| Application number(s): | 23/02338/OUT |
| Application site: | Land West Of Oxford Close And North Of Corner Farm Station Road Kirtlington |
| Proposal: | Erection of 15 detached and semi-detached single and two-storey dwellings (including affordable housing) together with access, parking, amenity space and landscaping - re-submission of 22/03049/OUT |

Date: 16/11/2023

Drawing Title:
 PROPOSED
 SITE PLAN
 COLOUR
 (ILLUSTRATIVE)

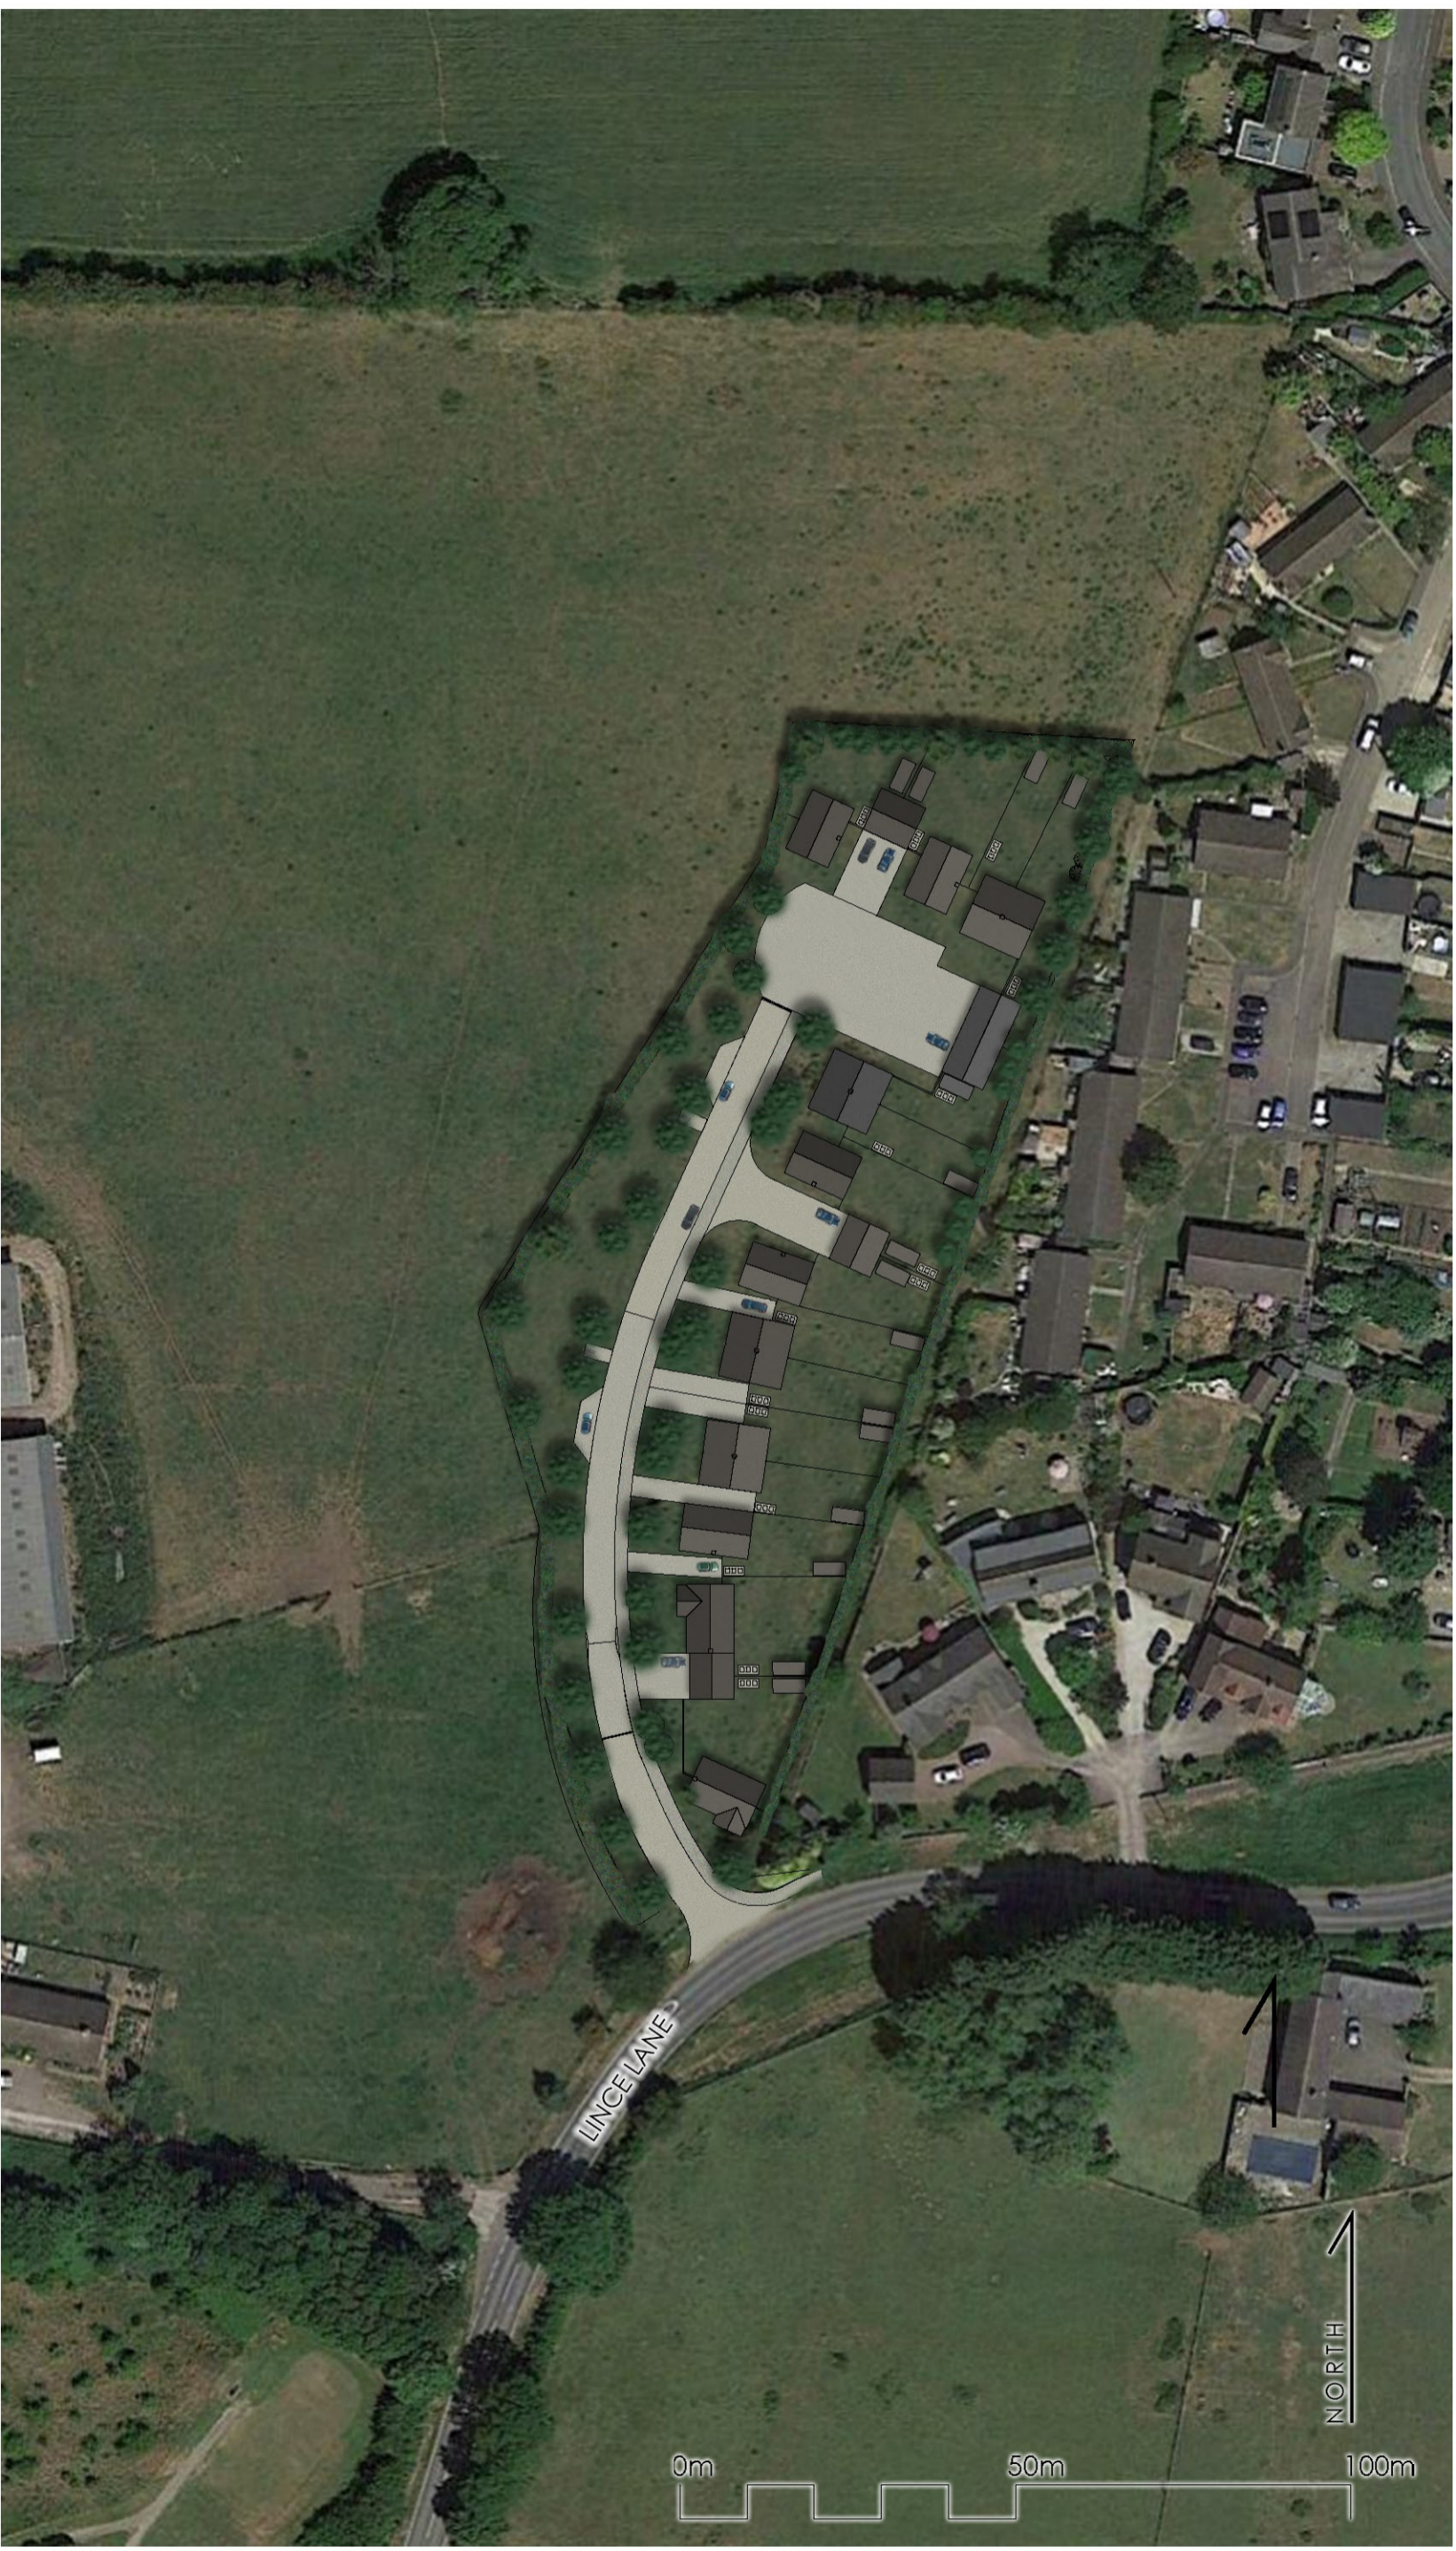
With regards to the proposed layout of the development, the provision of green space to the west of the access road is considered to potentially soften this boundary with the countryside. Also keeping the new dwellings closer to the existing built form of the village may help to reduce the prominence of the new development. The treatment of this space and boundary will therefore be important.

It is recognised that this application is an outline application to include means of access and layout, therefore the plans are somewhat indicative at this stage. However there are aspects of the proposals that would need to be carefully considered at the reserved matters stage, these include: the treatment of the access from Station Road, the boundary treatments, landscaping, design, and materials used. These details will be key to ensuring a positive form of development. The spaces need to be carefully designed to retain openness and ensure that the conservation area is not impacted as a result of development within its setting.
